TCL LETTER RESPONSE

Date: 03/06/2024

Project: **Mesa del Sol – Tract A**
Project No.: 22-0148

To: City of Albuquerque Plan Reviewer

## PARKING DATA

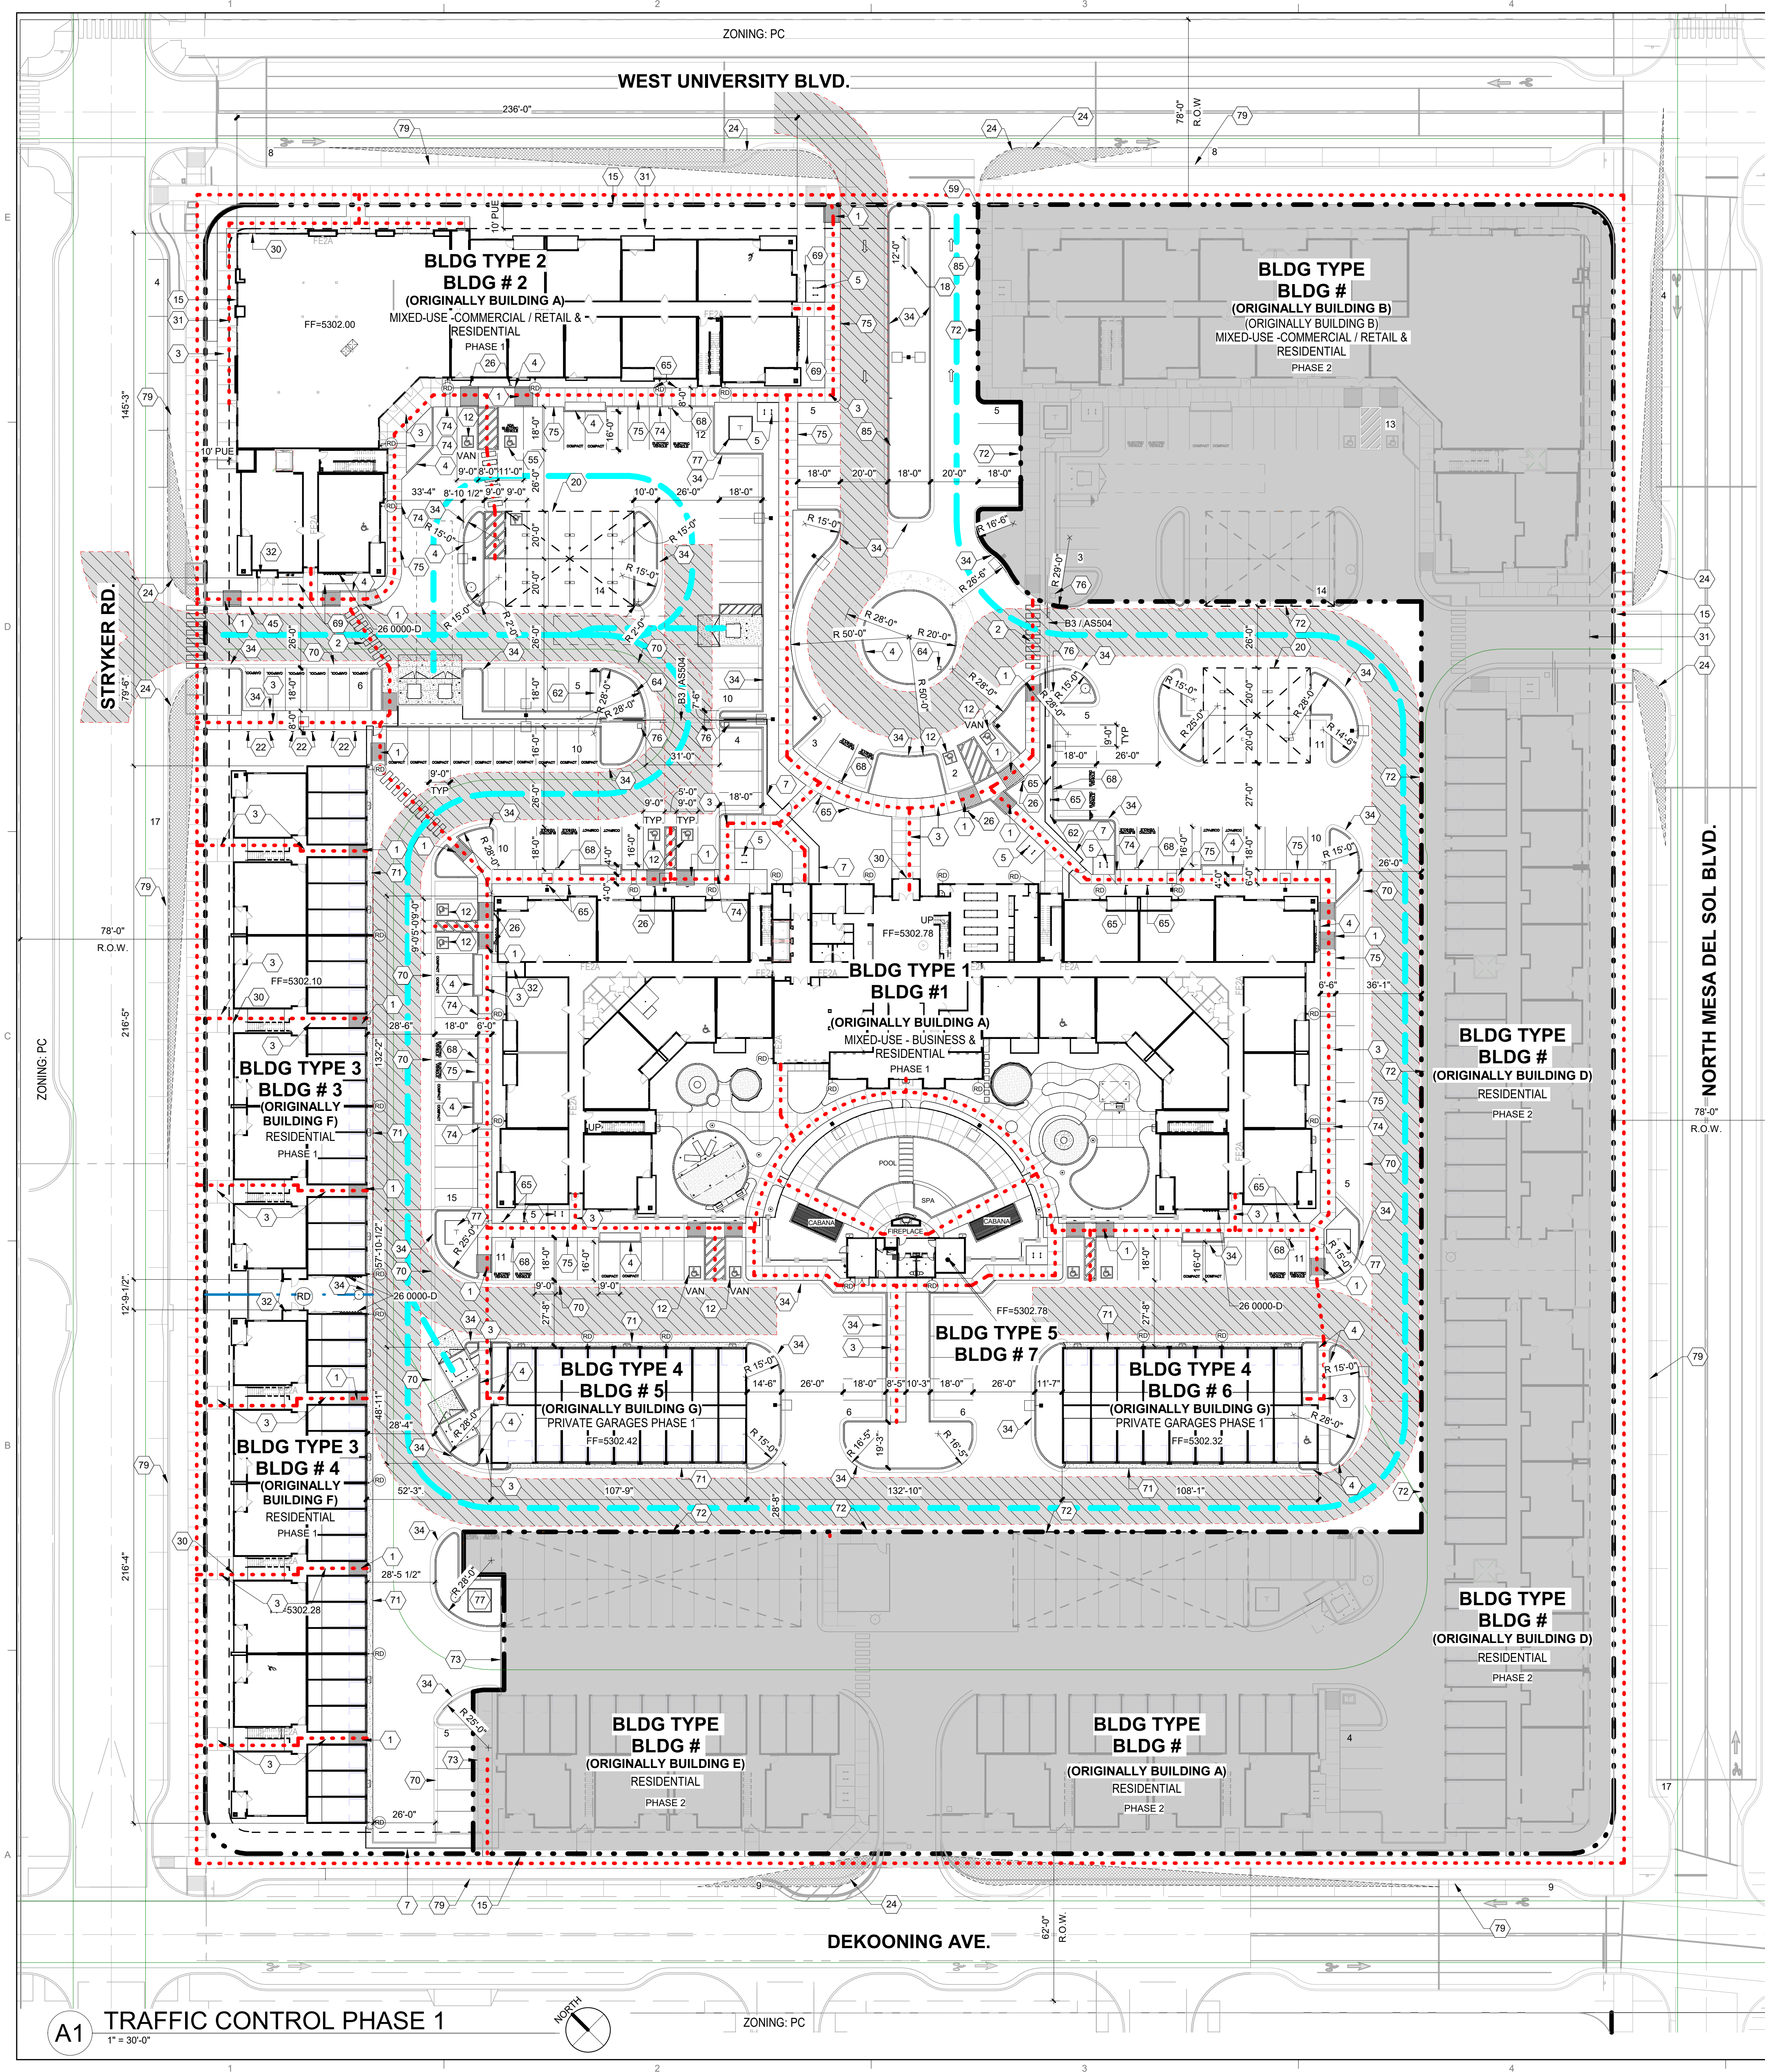
| | <u>REQUIREMENT</u> | <u>TCL RESPONSE</u> |
|---|---|--|
| 4 | Parking table: <ol style="list-style-type: none"> 1. There is no “No Requirement”. Per Mesa Del Sol Level B Plan, there is “No minimum parking requirement.” 2. Bicycle Parking: One Bicycle space shall be provided for every 10,000 sf of building net floor area. Please include this calculation in the Parking table. 3. Keynote 28: Please indicate on the parking table the number of EV parking spaces required. | <ol style="list-style-type: none"> 1. Parking table has been revised as noted. 2. Bicycle parking requirement updated. 3. EV parking spaces required updated and noted in the parking data. |

A1 OVERALL SITE PLAN  
1" = 50'-0"

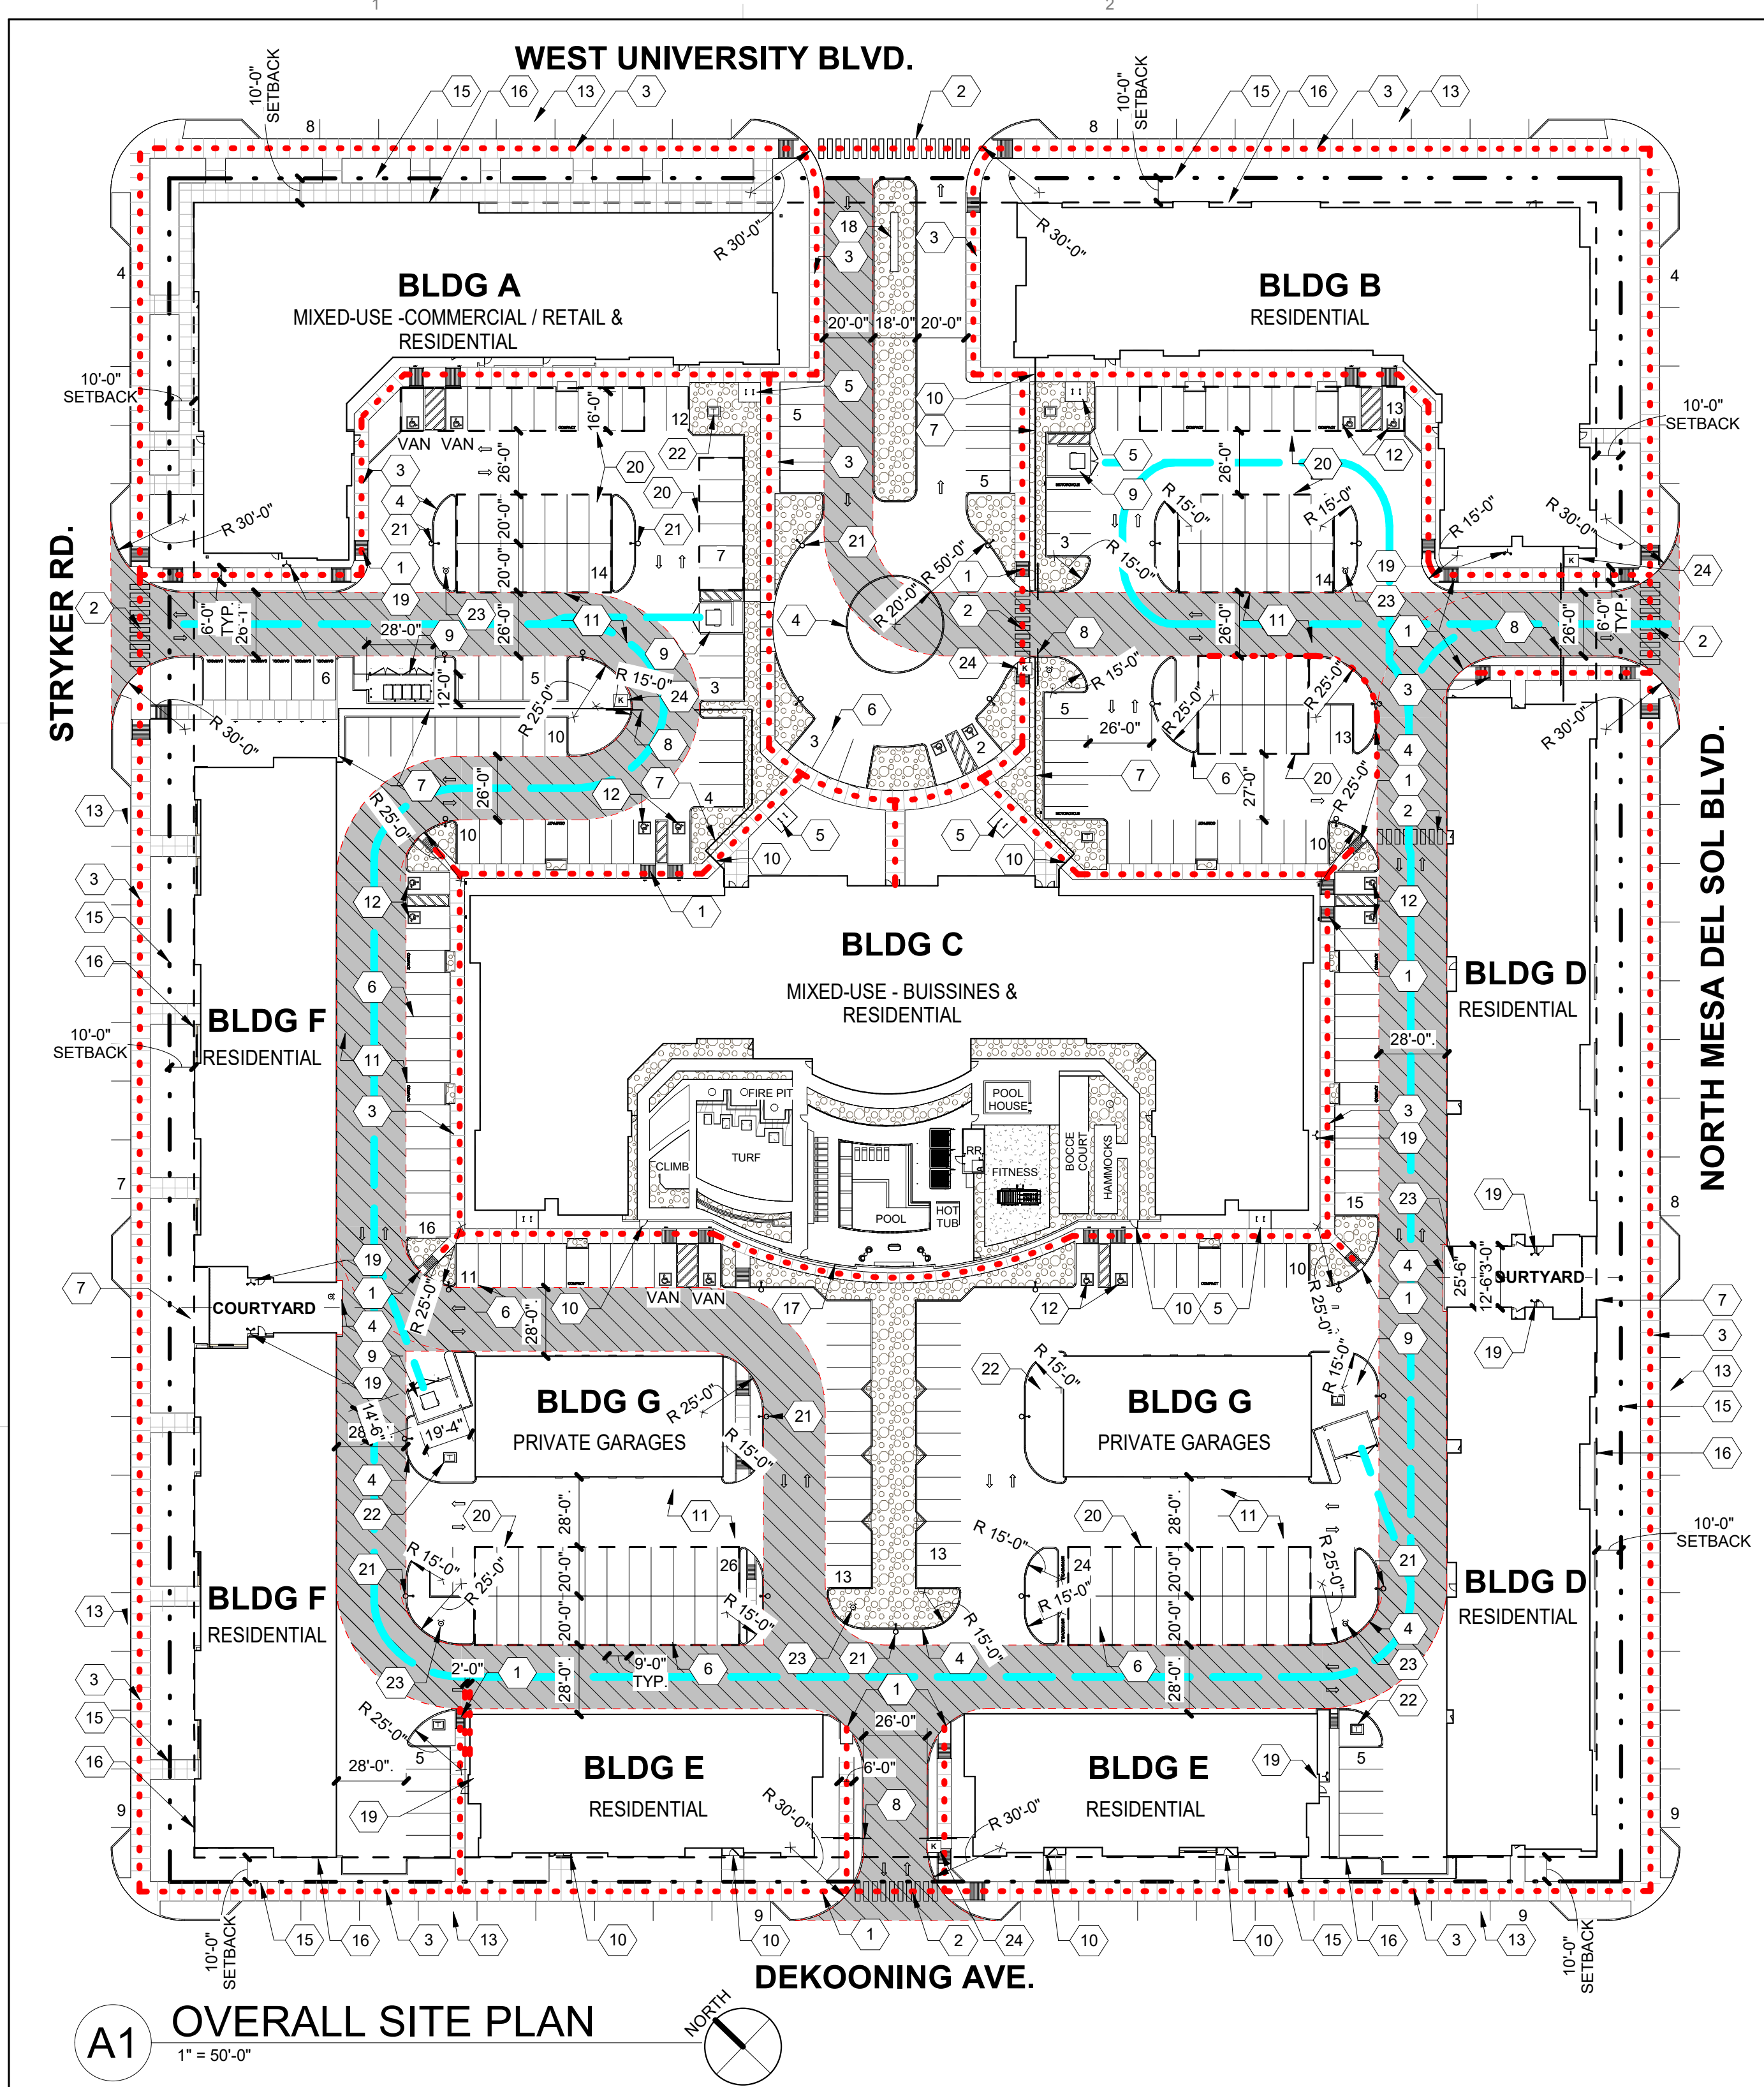
| | <u>REQUIREMENT</u> | <u>TCL RESPONSE</u> |
|---|---|--|
| 3 | Show on the site plan the length of the no parking zone at the corner of Dekooning Ave. and North Mesa Del Sol Blvd. | Site plan has been revised as noted. |
